**A66 Northern Trans-Pennine Project
TR010062**

**8.1 Change Application – Appendix A:
Schedule of Consequentially
Amended Application Documents
(Rev 3)**

06 April 2023

**8.1 CHANGE APPLICATION – APPENDIX A: SCHEDULE
OF CONSEQUENTIALLY AMENDED APPLICATION
DOCUMENTS**

Map Number	Project	Originator	Volume
HE565627	-	AMY	EAQ
S00	-	MP - LA	002017
Location		Type	Role
Suitability	S4	Suitability Description	Revision
		FIT FOR STAGE APPROVAL	P03

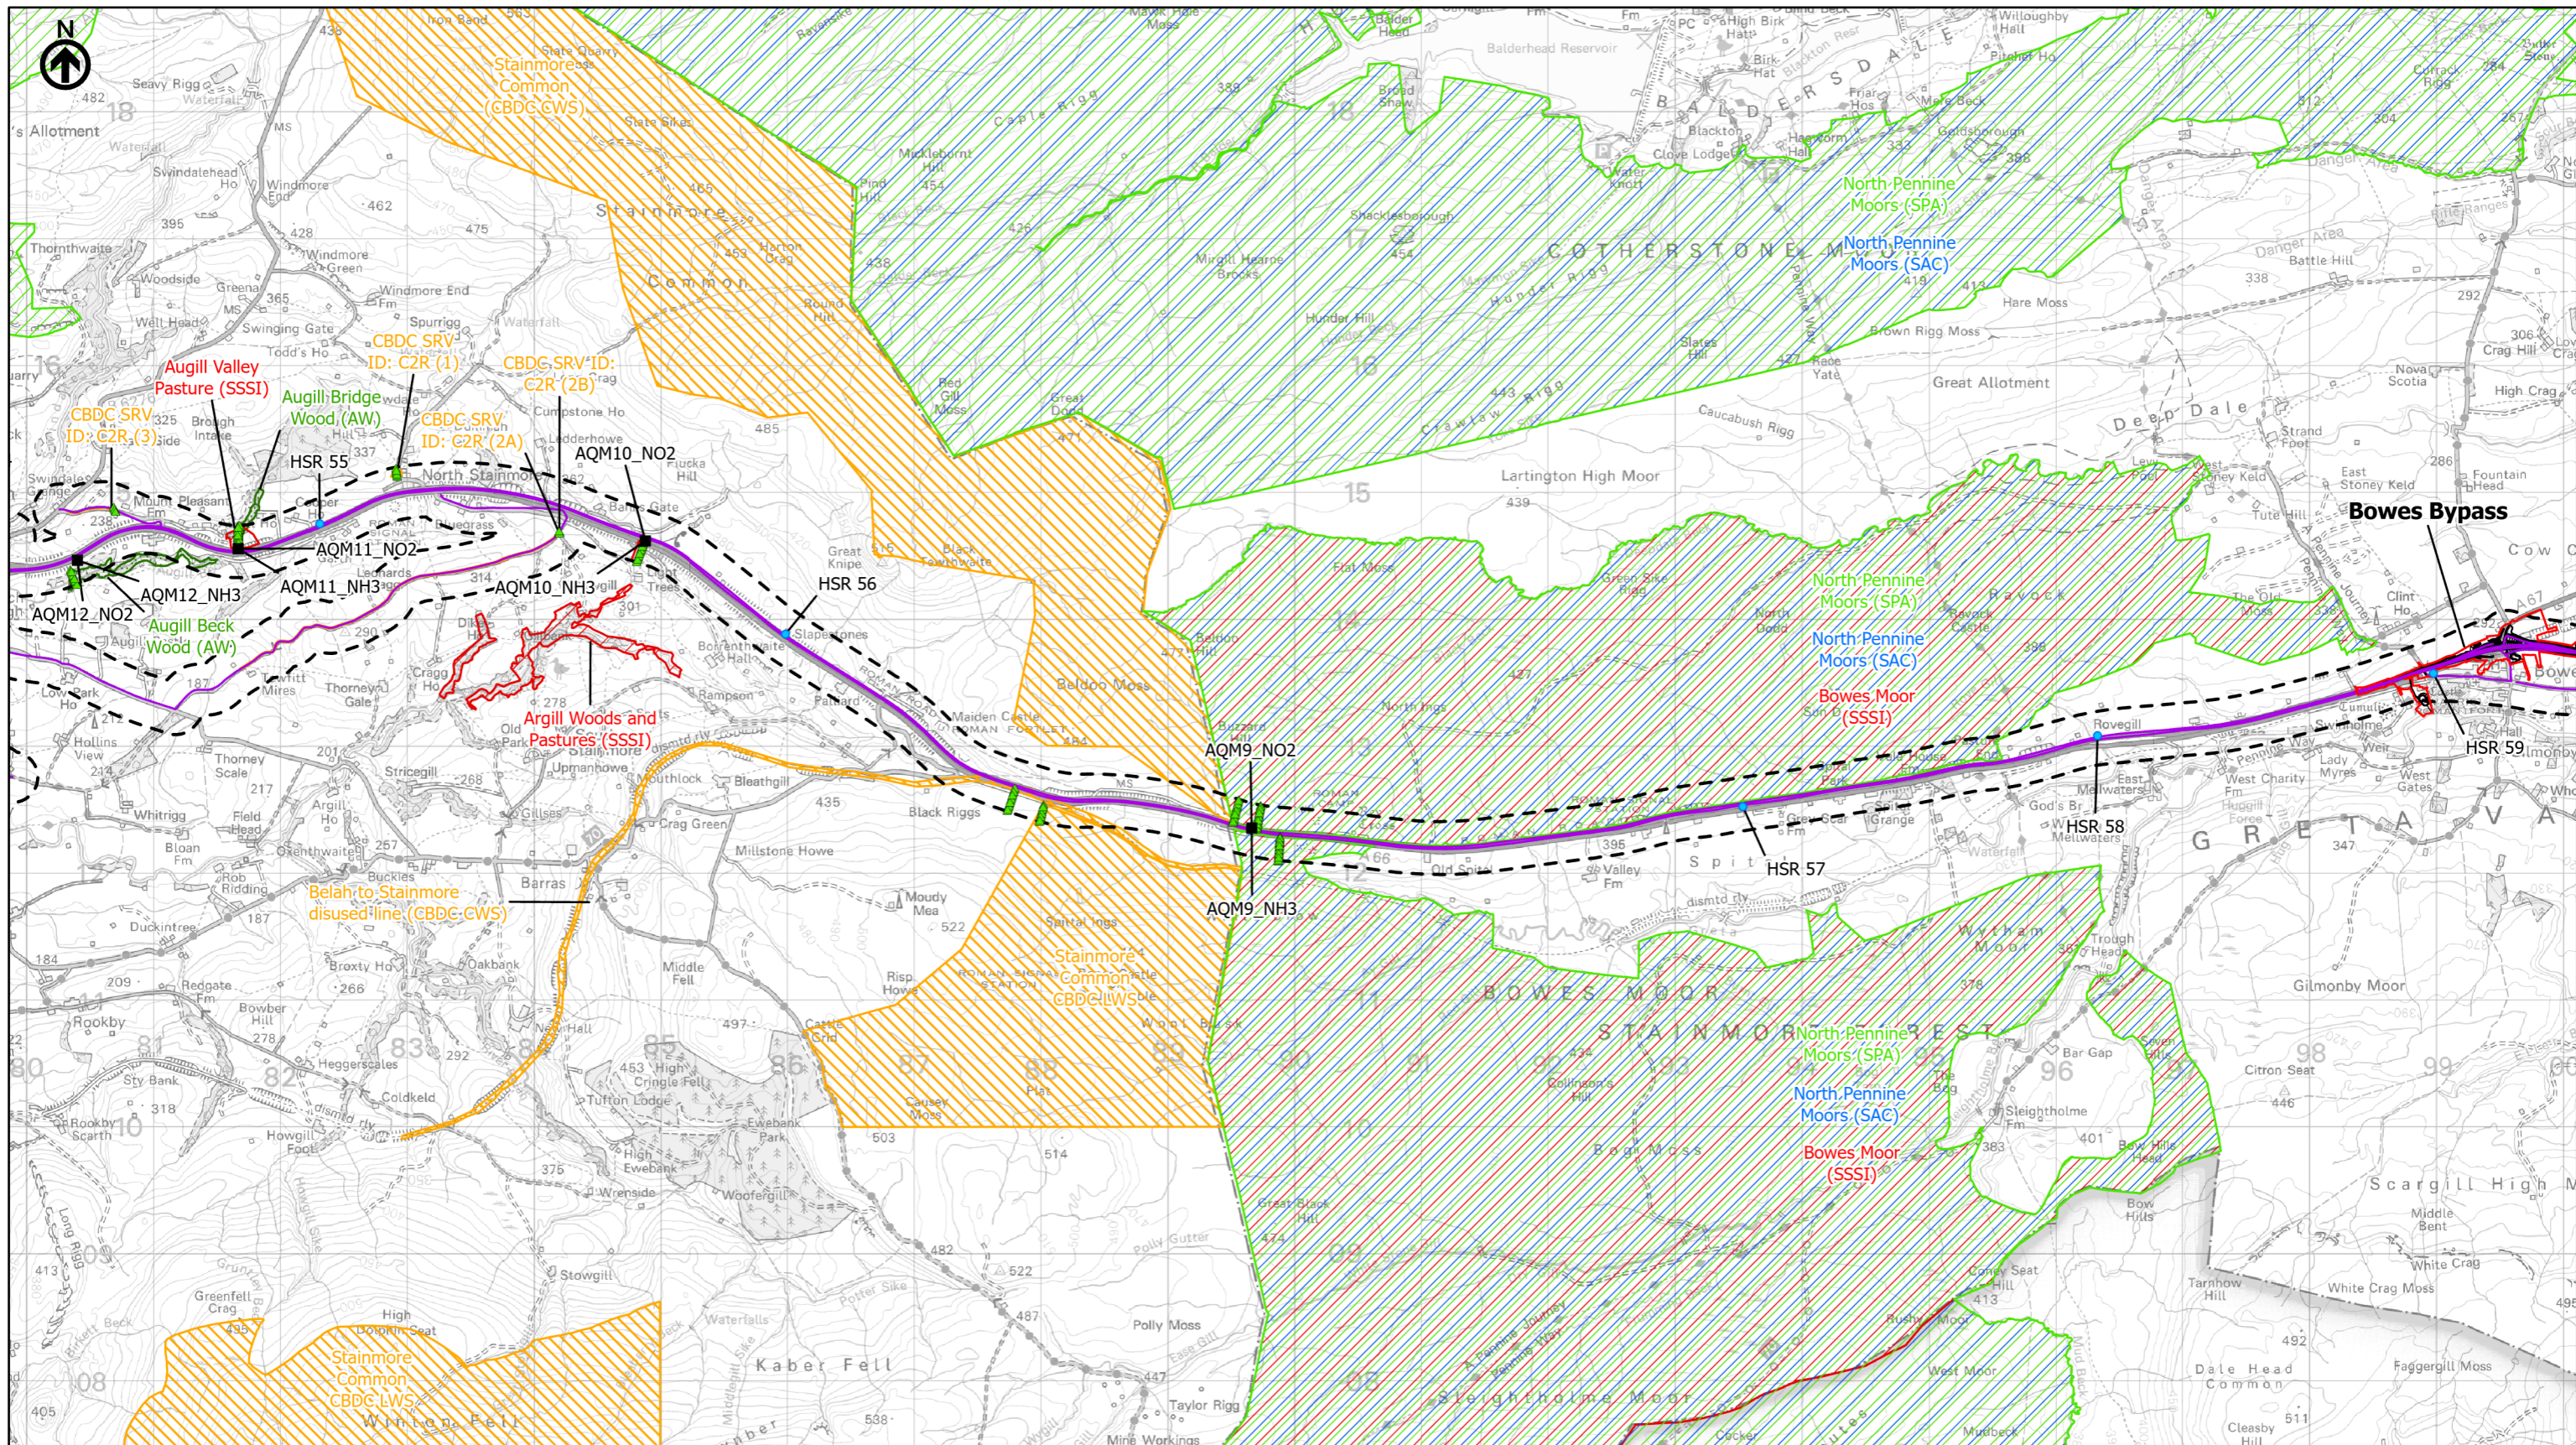
3.3	APP-065	Environmental Statement Figure 5.1 Air Quality Study Area and Constraints	Amendments required to show revised Order limits on sheets showing Scheme 06	Amendments required to show revised Order limits on sheets showing Scheme 06

Project Name A66 Northern Trans-Pennine Project			
Map Title Figure 6.3			
Scheme: 06, Appleby to Brough			
Sheet 9 of 15			
Map Number HE565627	Project S00	Originator - AMY -	Volume - EBD -
Location		Type - MP -	Role - LB -
Suitability S4		Description FIT FOR STAGE APPROVAL	
Revision P03		Revision

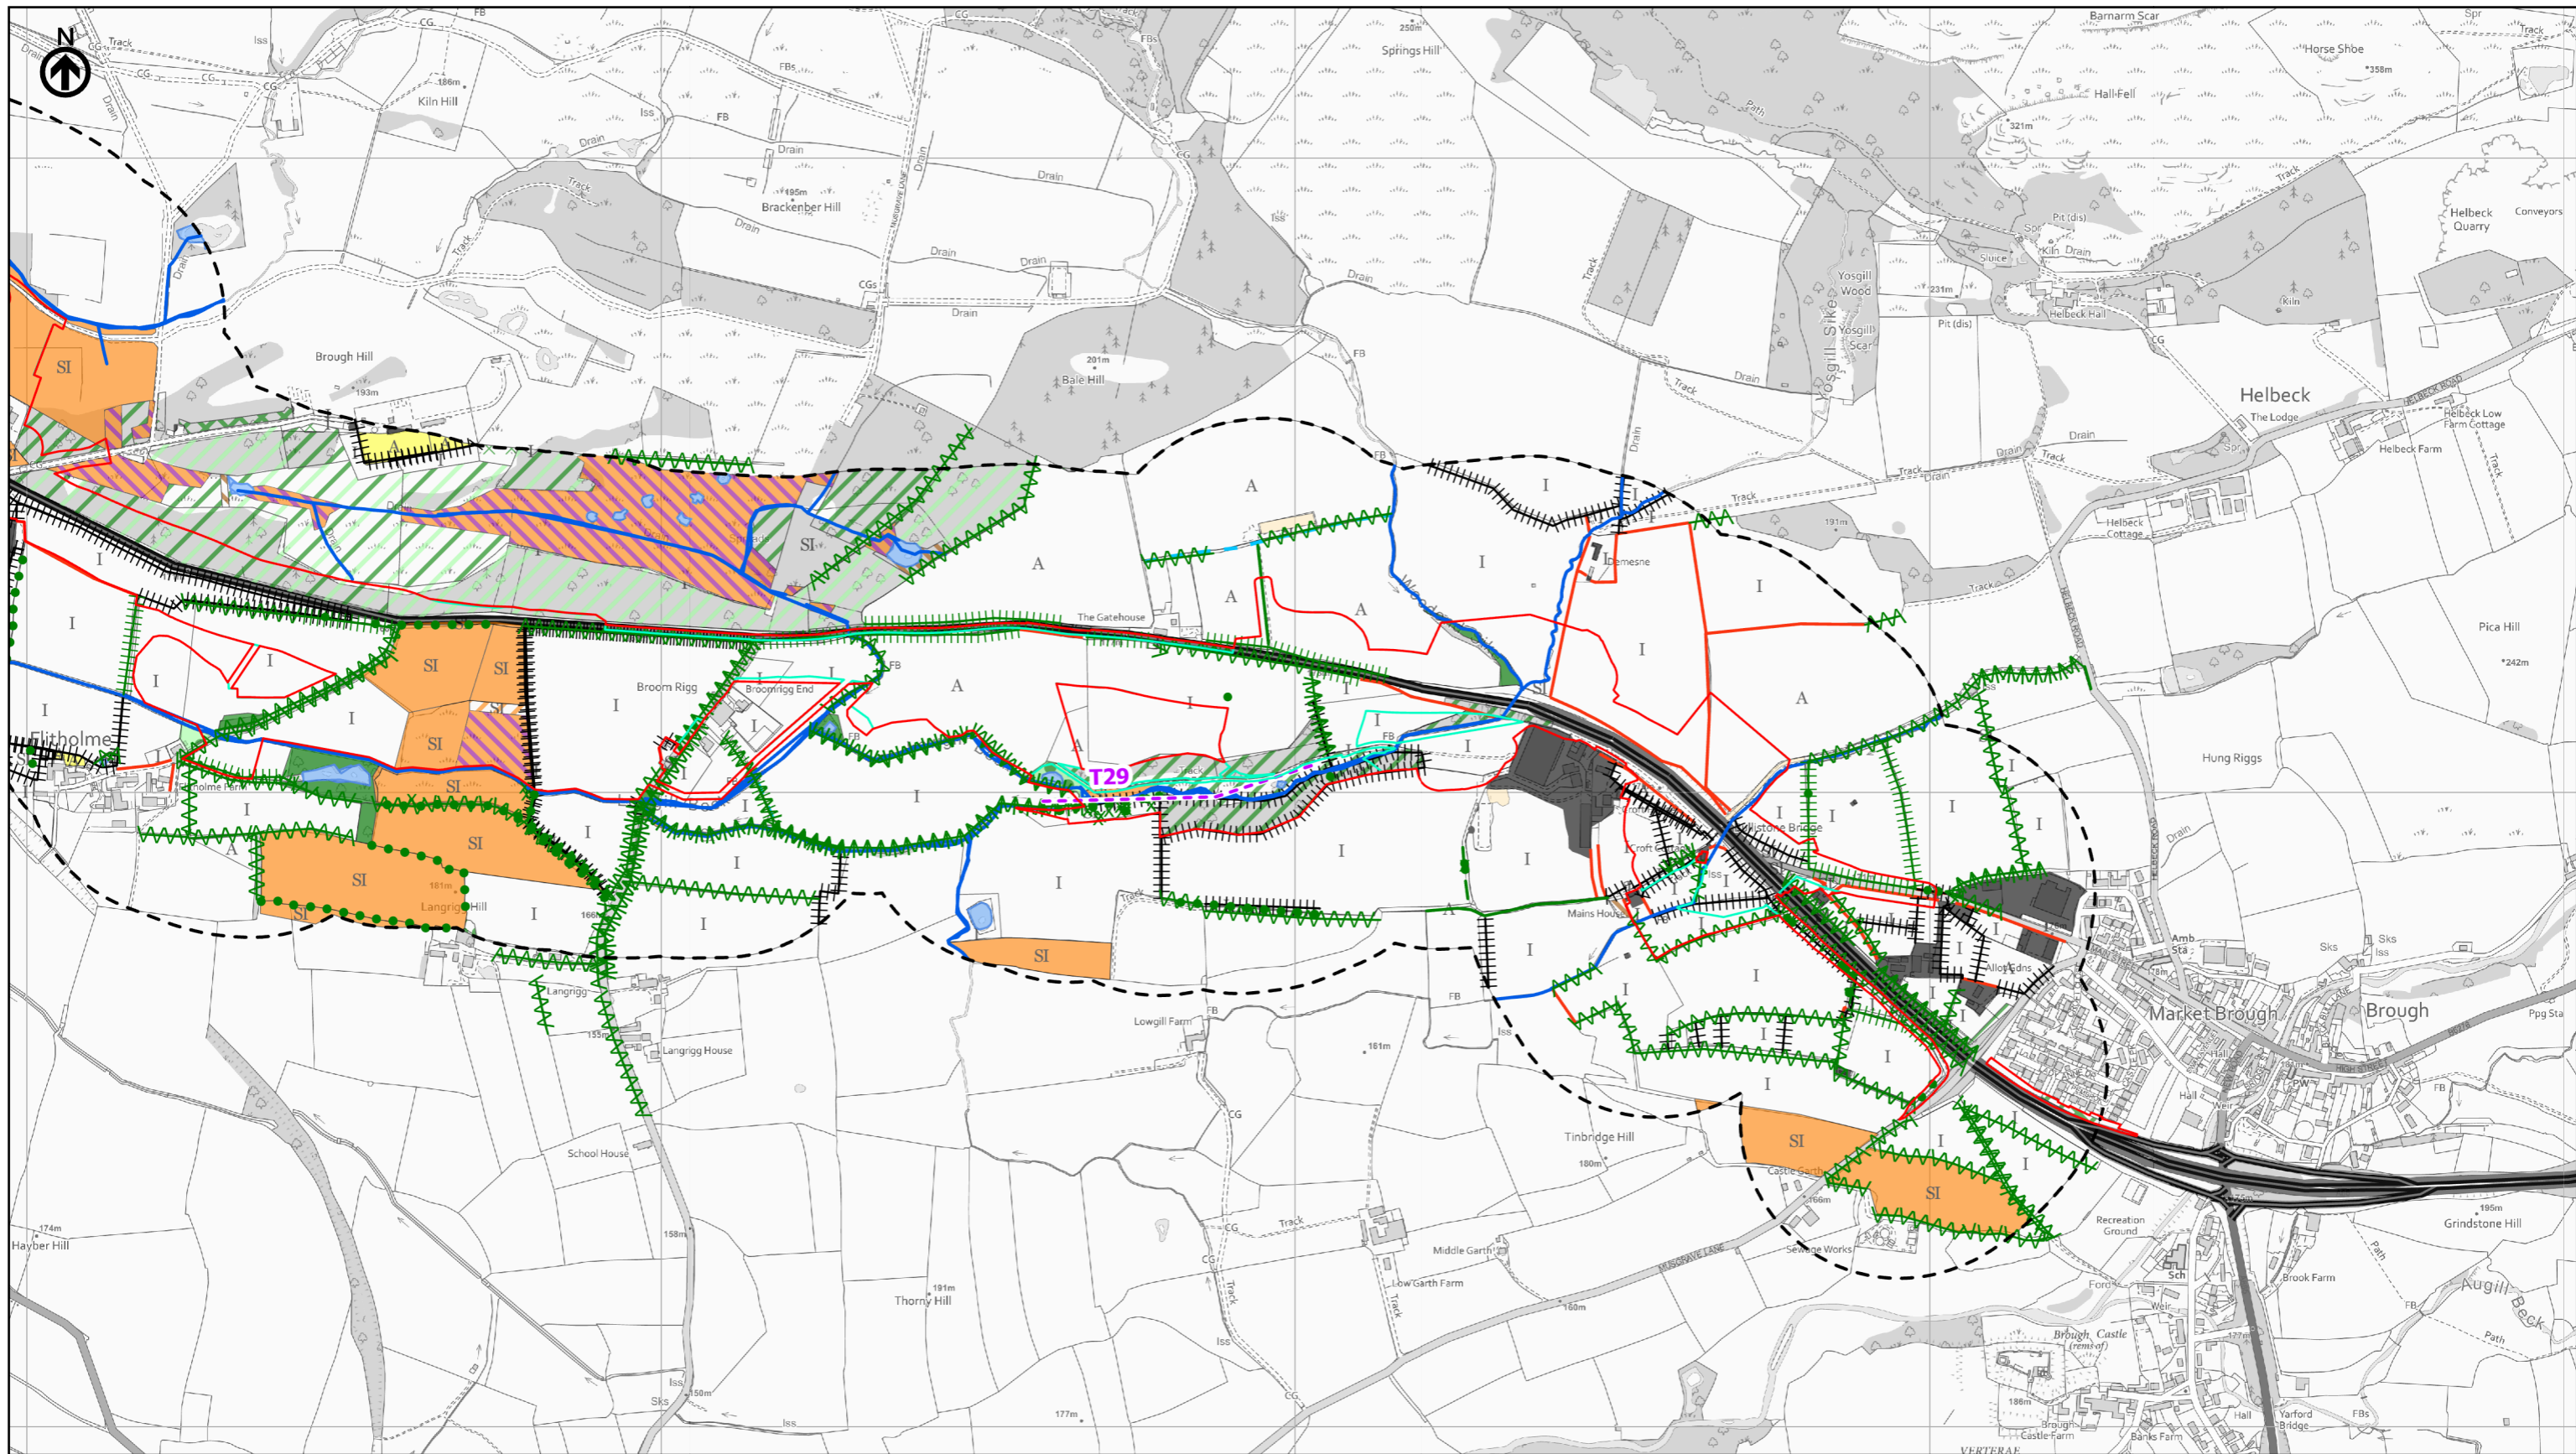
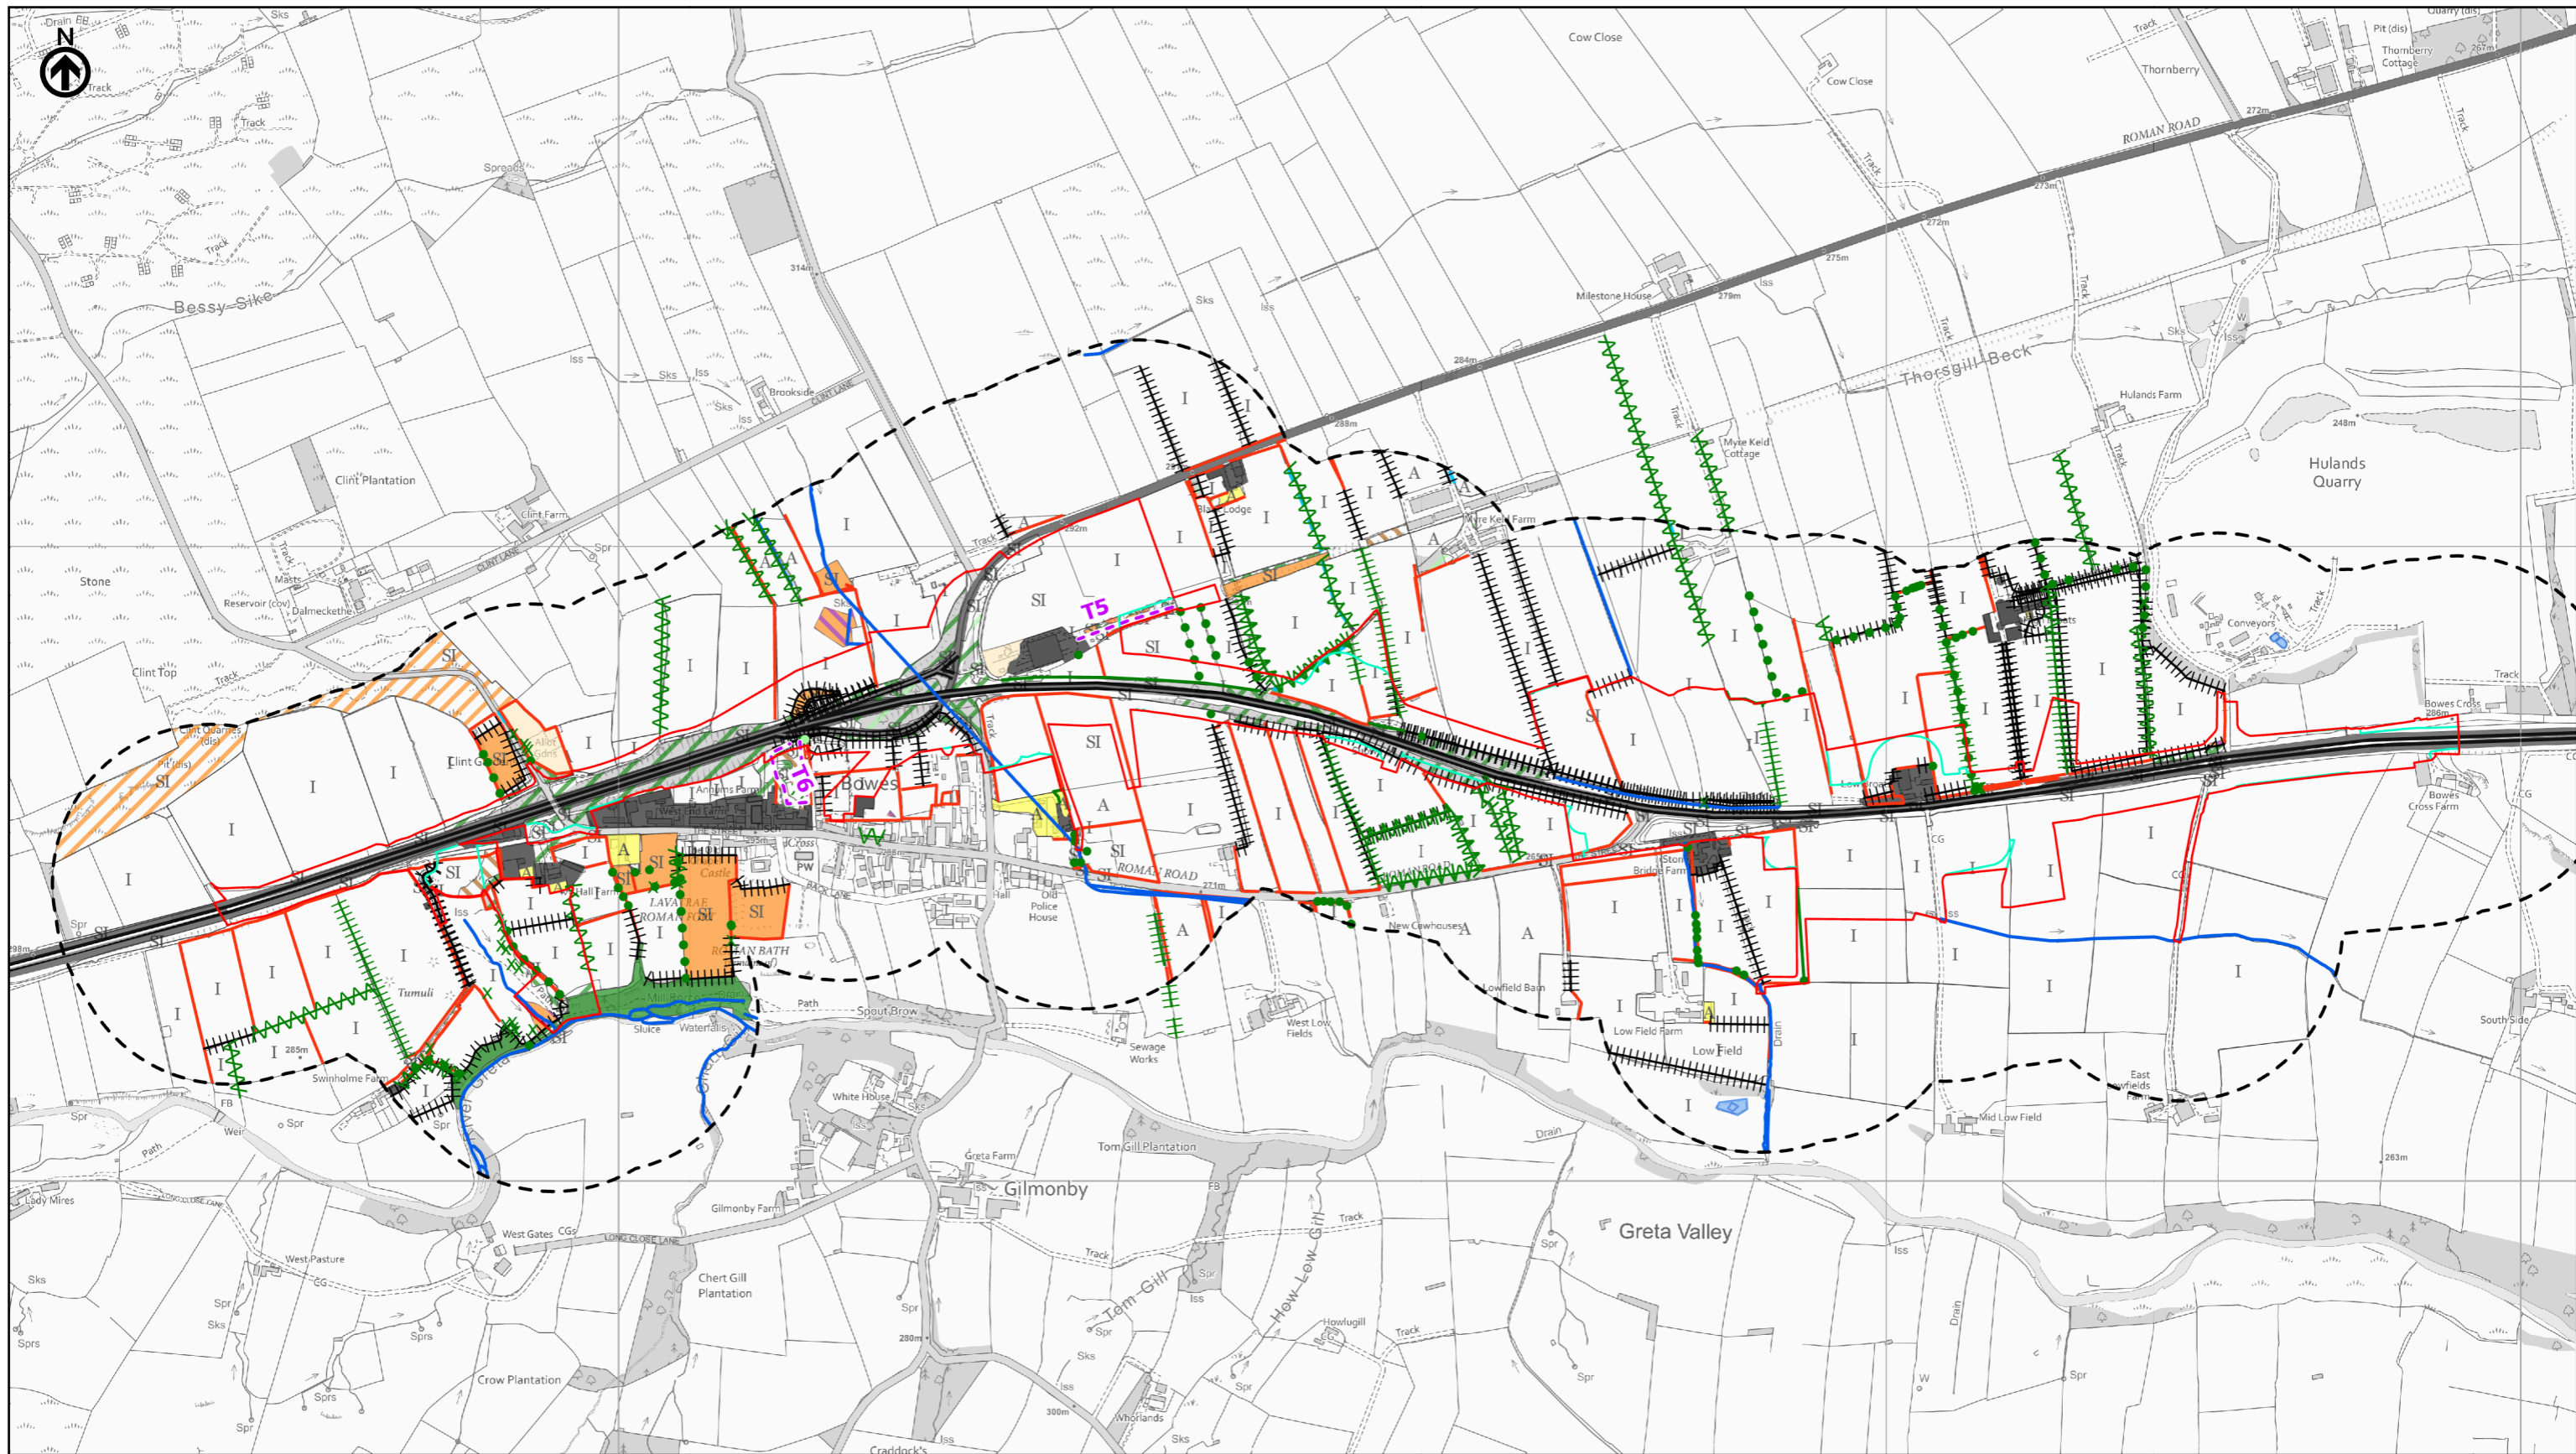
3.3	APP-071	Environmental Statement Figure 6.3 Phase 1 Habitat Terrestrial Invertebrates	Amendments required to show revised Order limits on sheets showing Scheme 06	Amendments required to show revised Order limits on sheets showing Scheme 06
